City of Albuquerque

December 10, 2002

RE: Grading and Drainage Plan for NAA, Lot 31, Block 17, Unit 3, Tract 1 (B20-D16)
Dated November 26, 2002

OFF-SITE DRAINAGE MAP
SCALE 1" = 200'

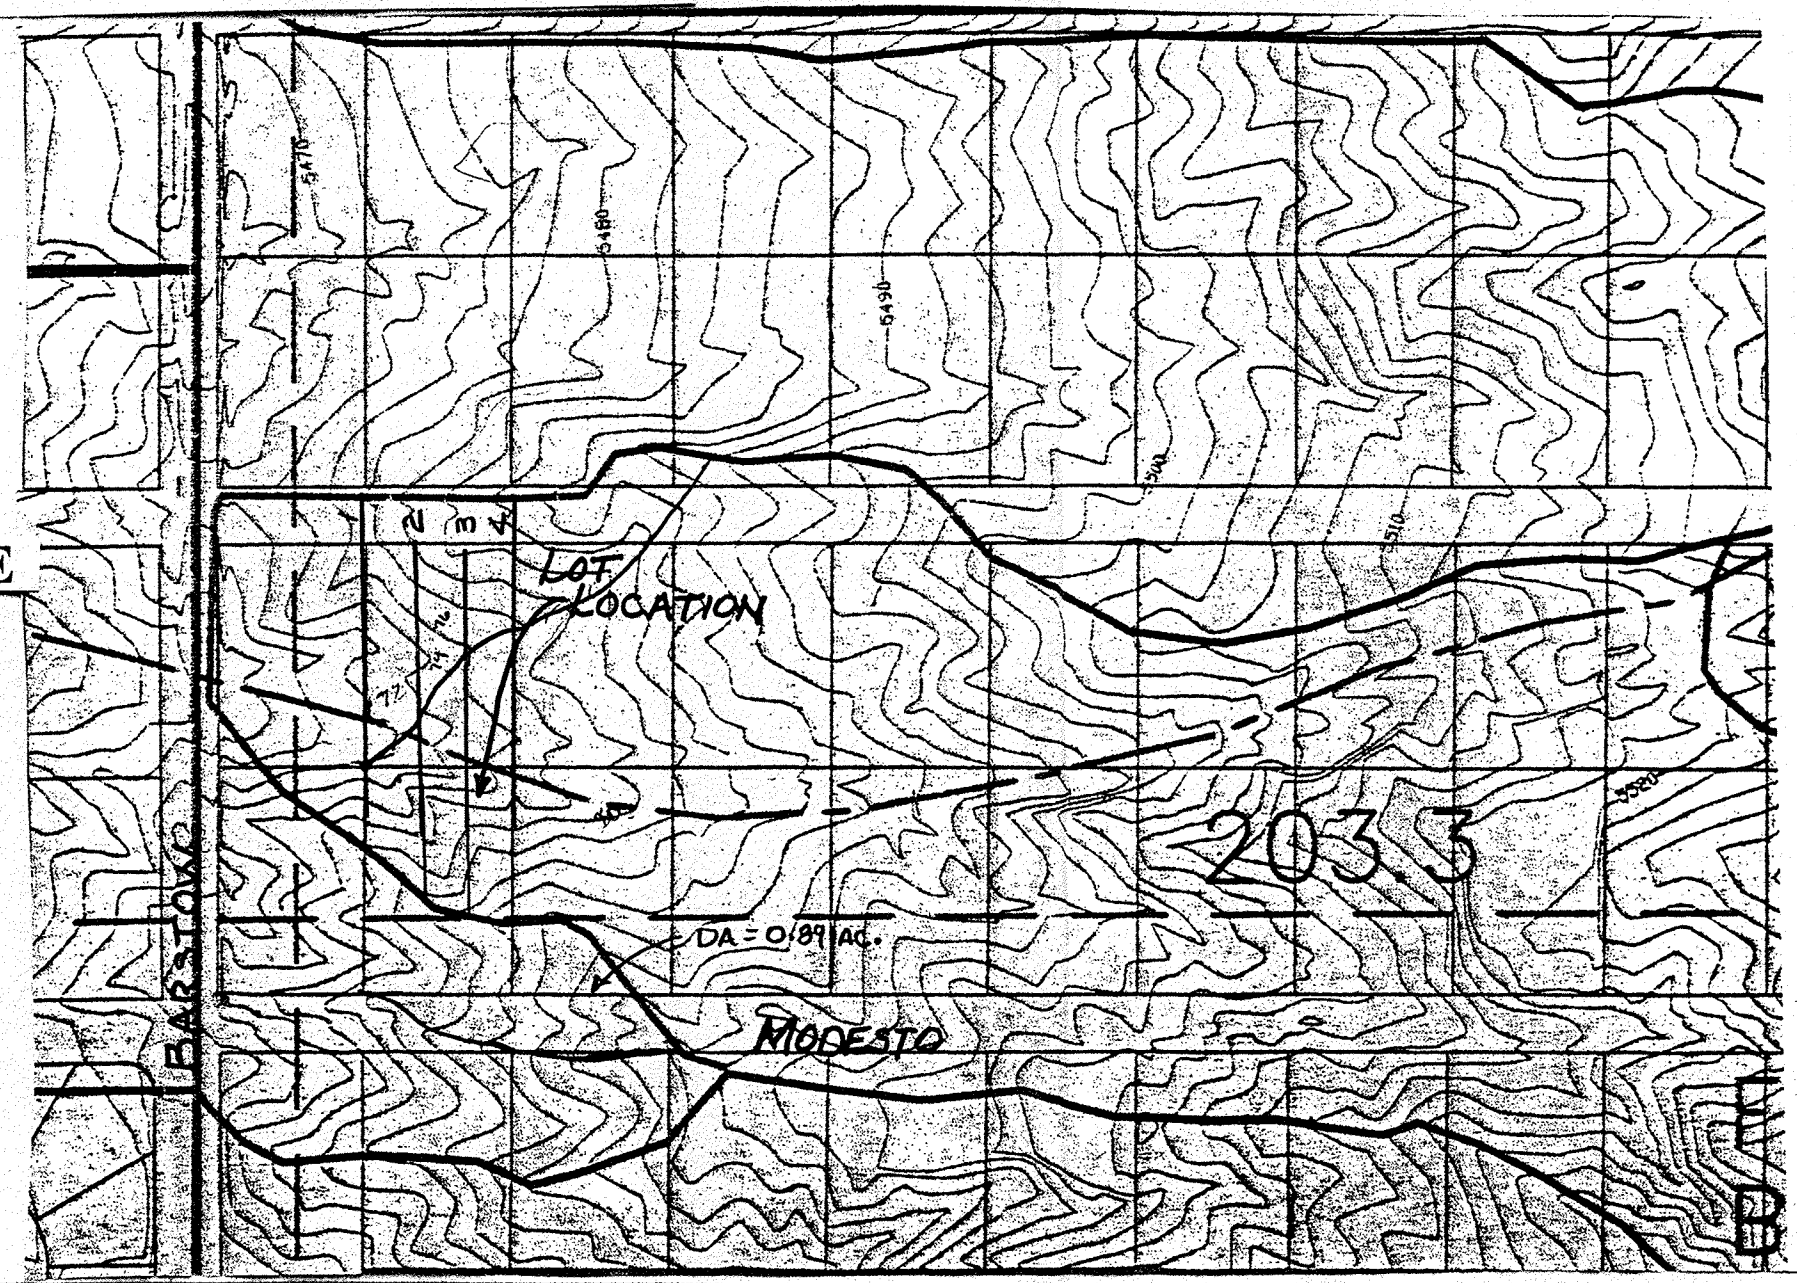
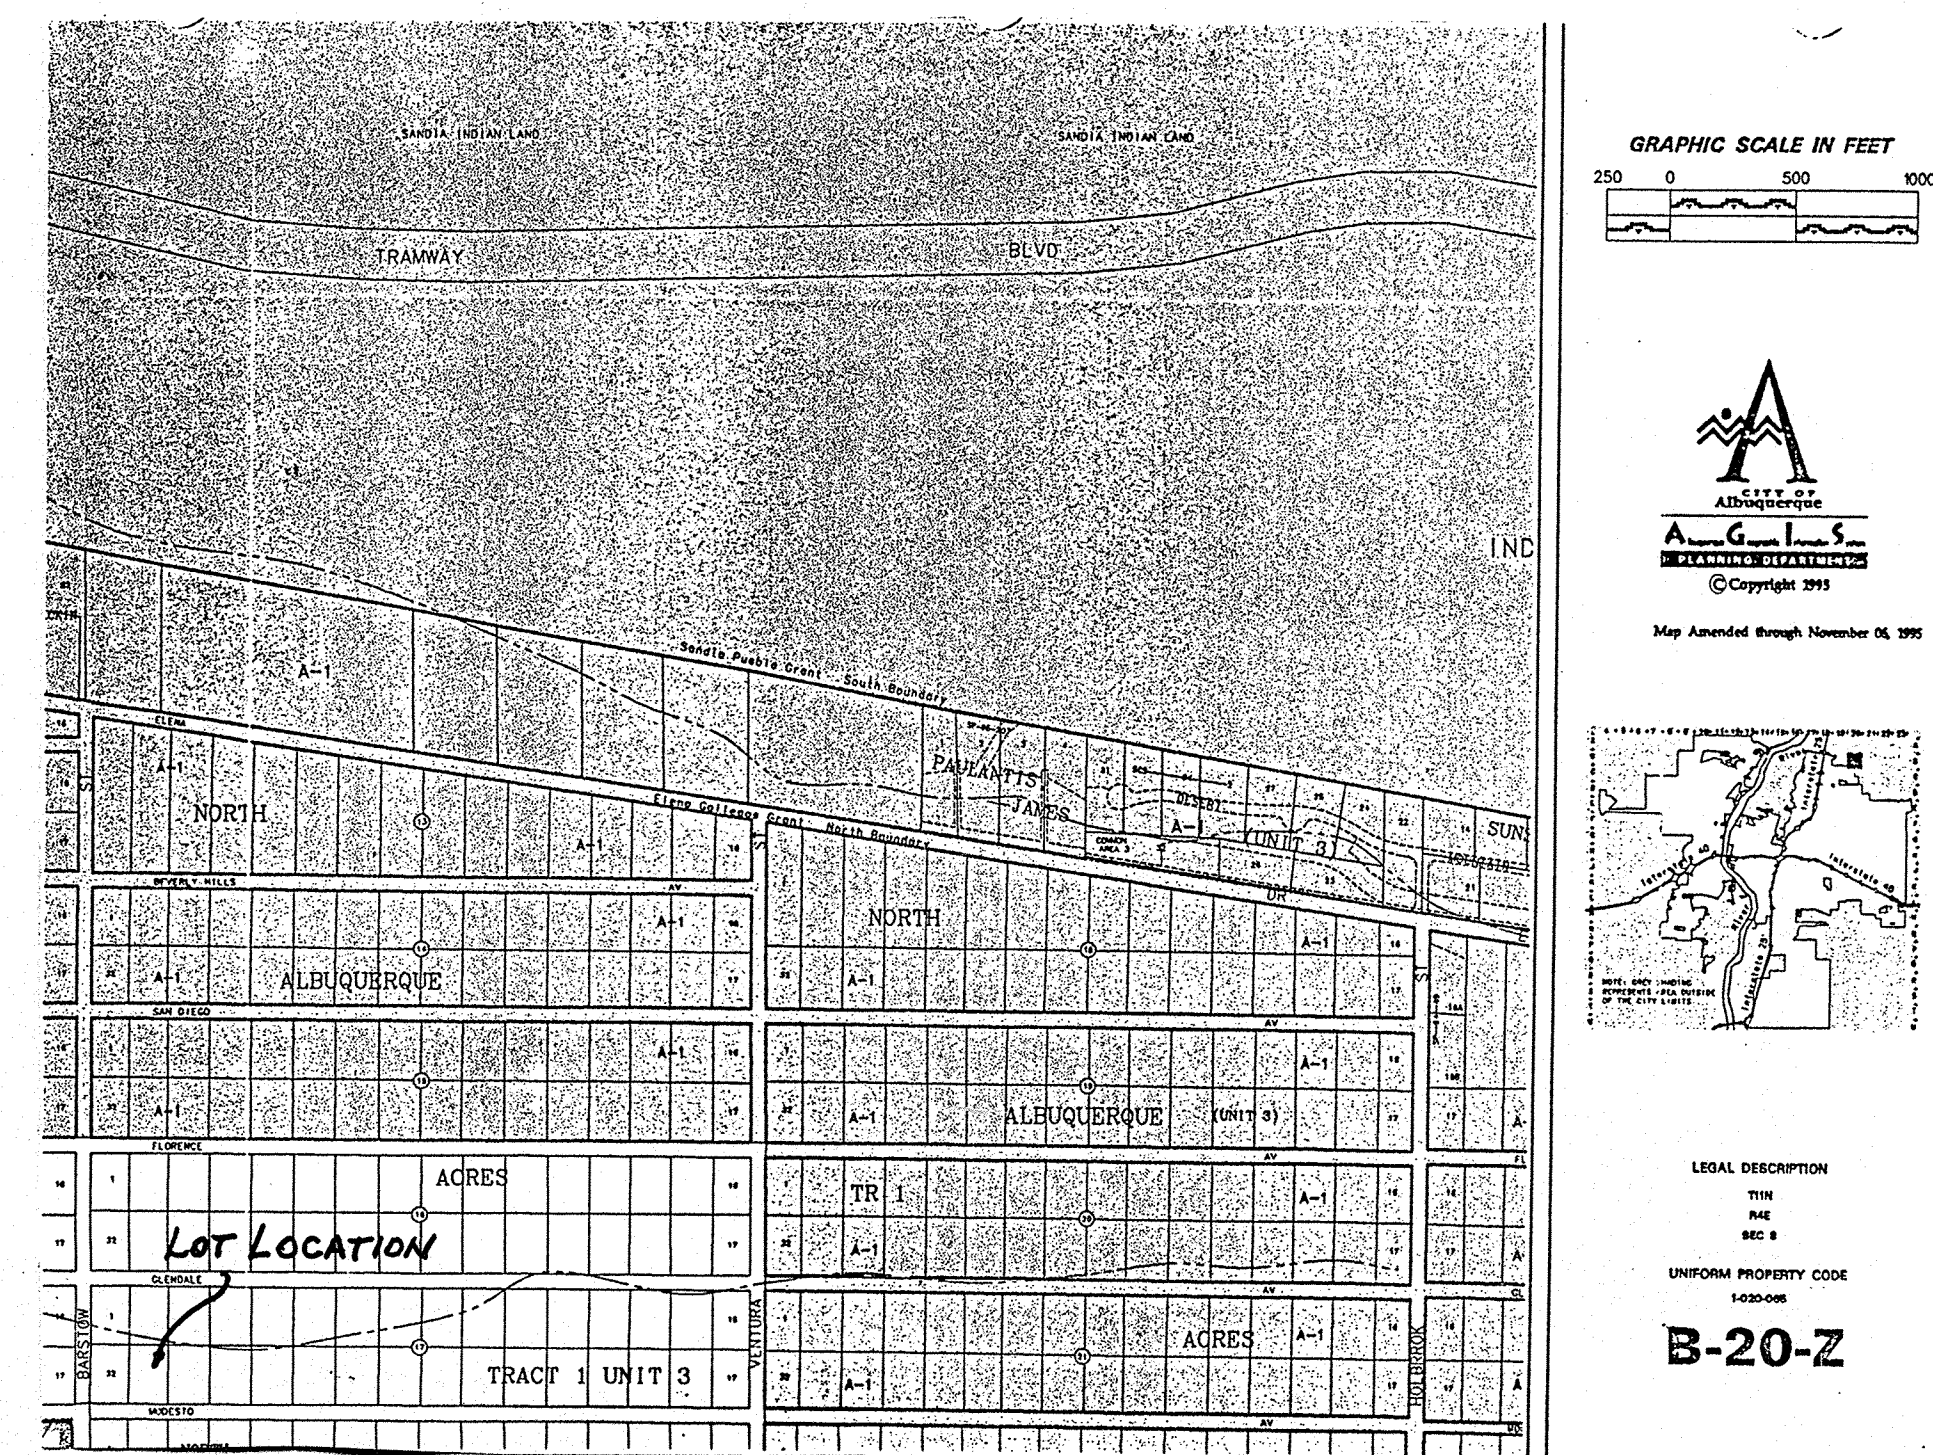
The above referenced plan received March 28, 2001 is approved for Building Permit. Upon completion of the project the engineer will need to certify the project. One item that I would like you to call me on is the small difference for the contours between the off-site drainage map and the grading plan. RTI's floodplain matches yours, but the HEC-RAS and the off-site drainage map elevations are slightly different.
